TOWN AND COUNTRY PLANNING ACT 1990 OUTLINE

Reference: H17-0021-24 **Date of Decision:** 1st March 2024
Applicant: Mrs J Beattie
C/O Jc Architectural Consultant
Rose Villa, Main Road
Holbeach Drove
Spalding
PE12 0PS
Location: 10 Gosberton Road Surfleet Spalding
Description: Residential Development of up to 4 dwellings

Indicative Front Elevation
Scale 1:100

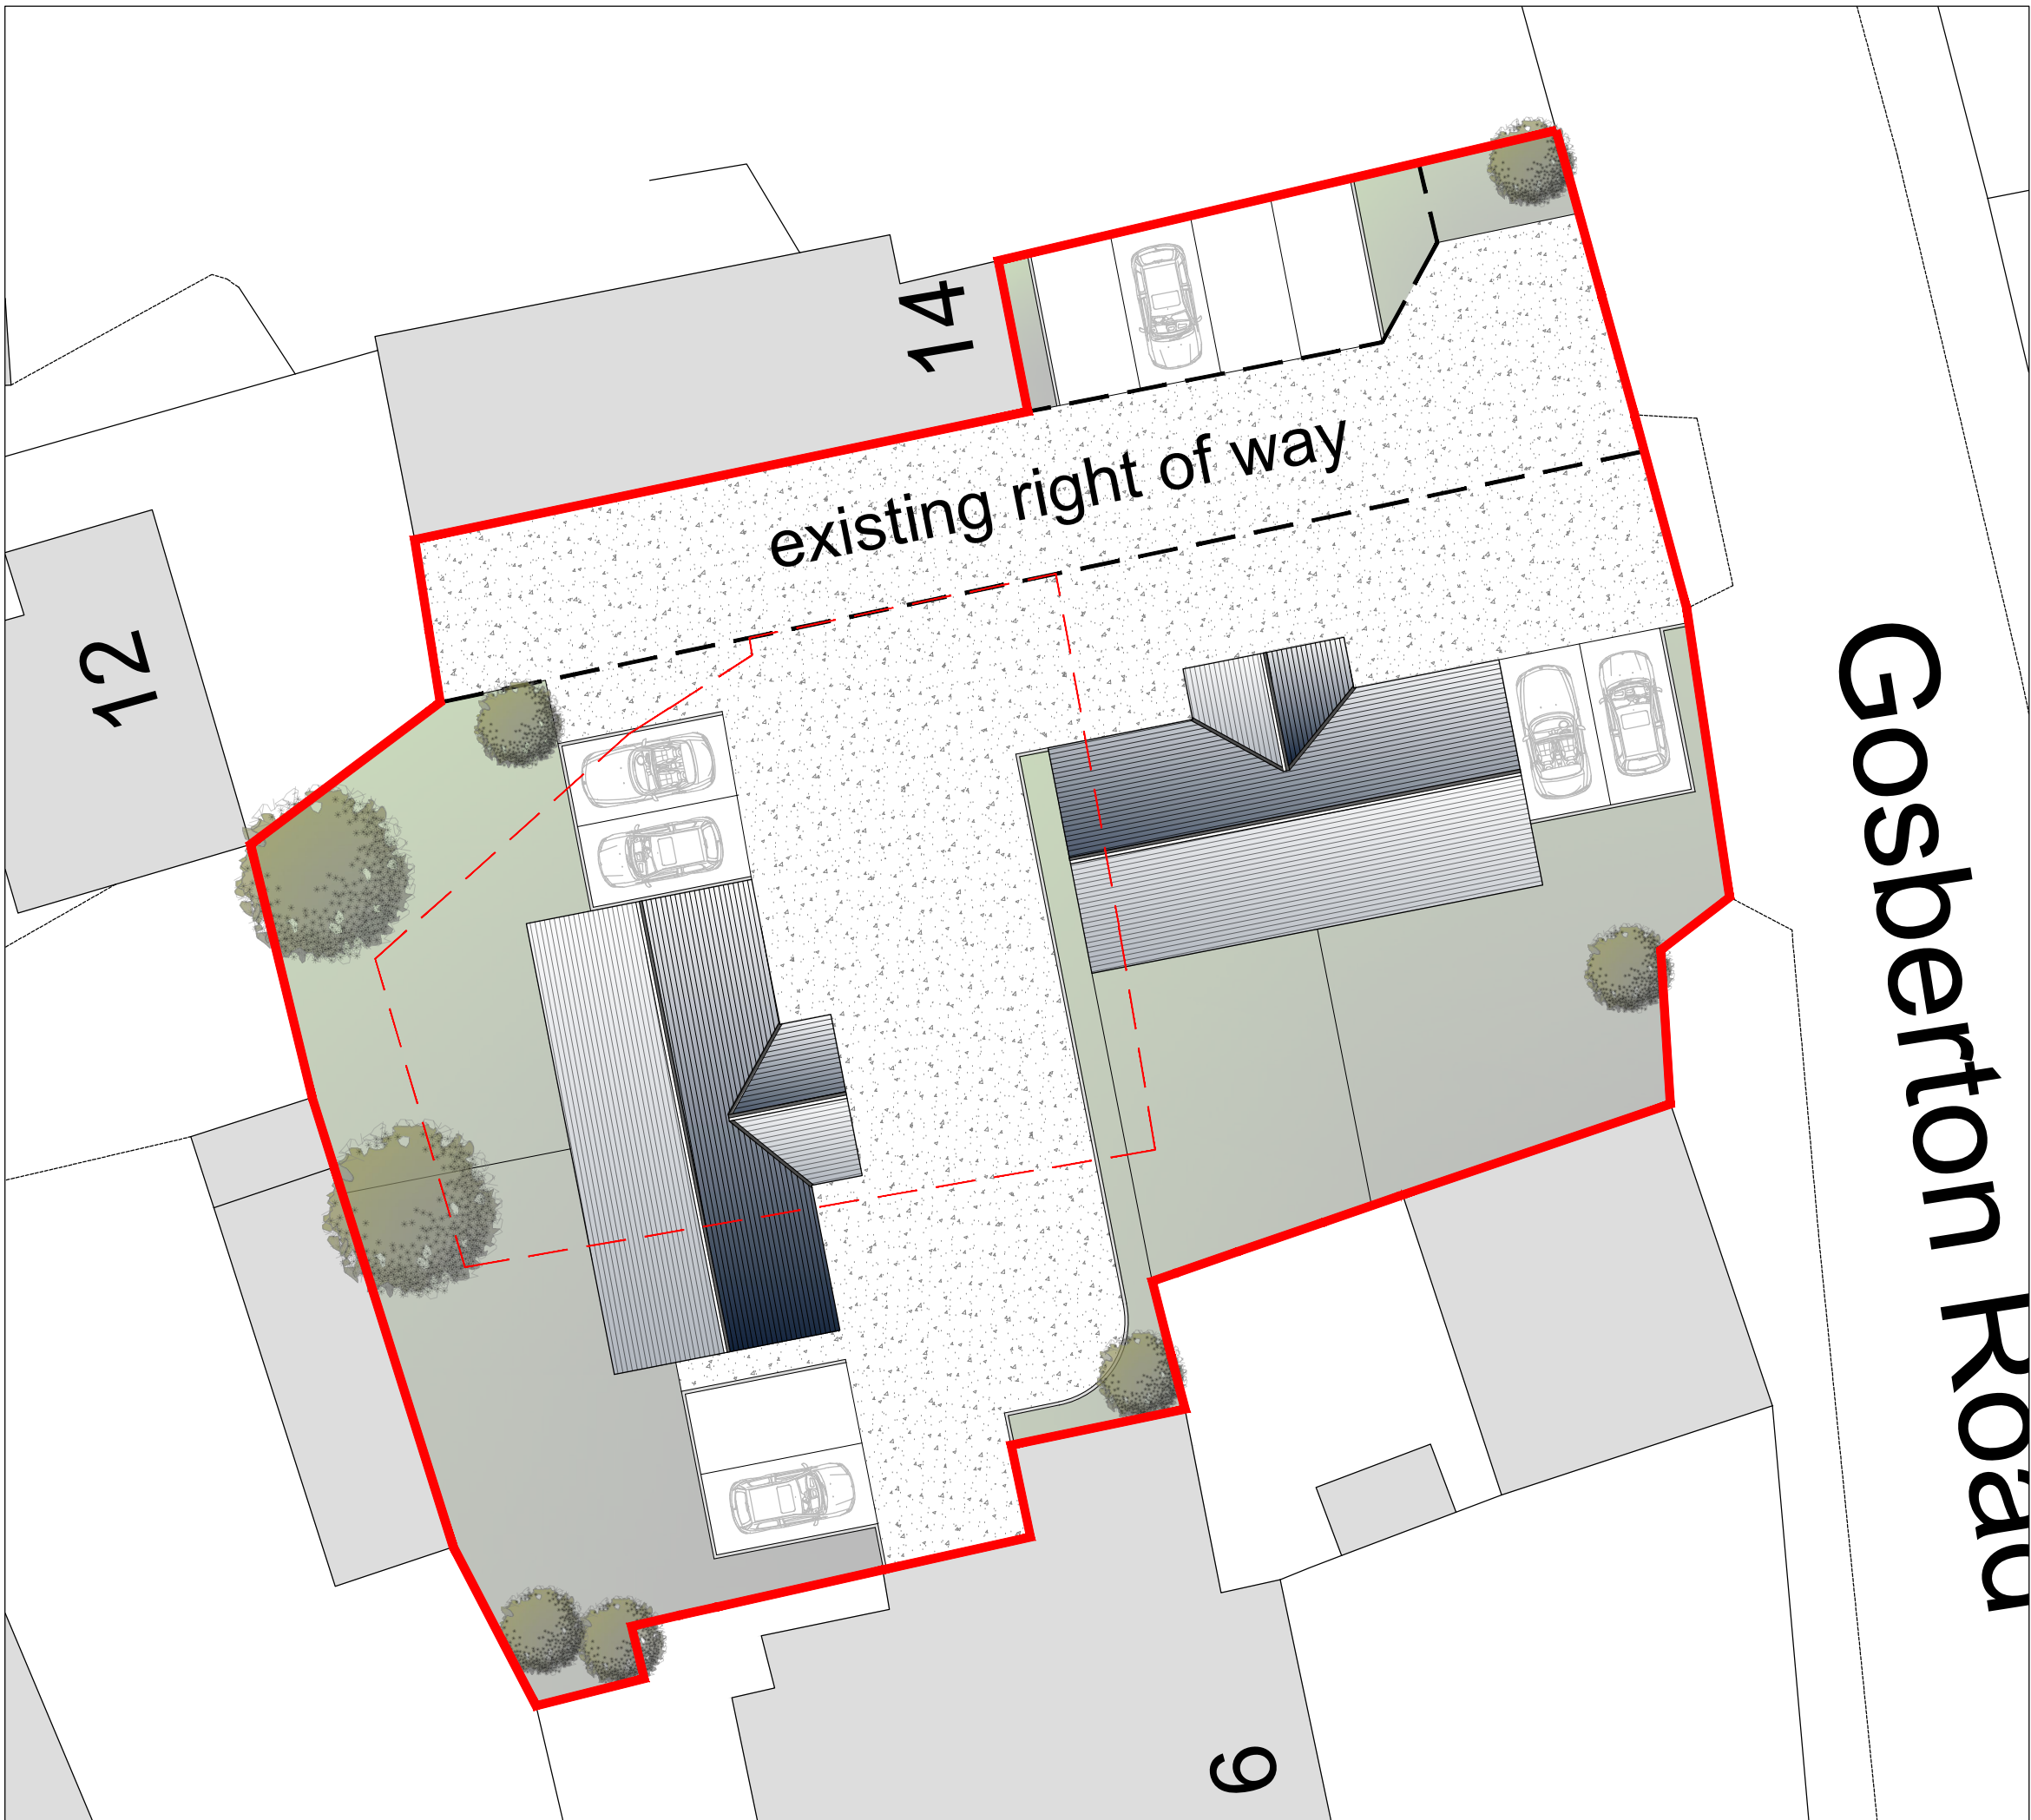
Whilst it is recognised this application is in outline form, the indicative elevations are too plain and lacking in sympathy with neighbouring development, particularly in relation to the position of the Grade I listed church opposite the site. Proposals should improve the qualities of the village, so a high quality of design will be expected of the final proposal to satisfy Policies 2 (Paragraphs 2 & 9), (Paragraph 1) and 19 of the SELLP.

The reserved matters application should address the issue of the need to maintain an adequate maintenance gap with the proposed residential properties and number 8 Gosberton Road.
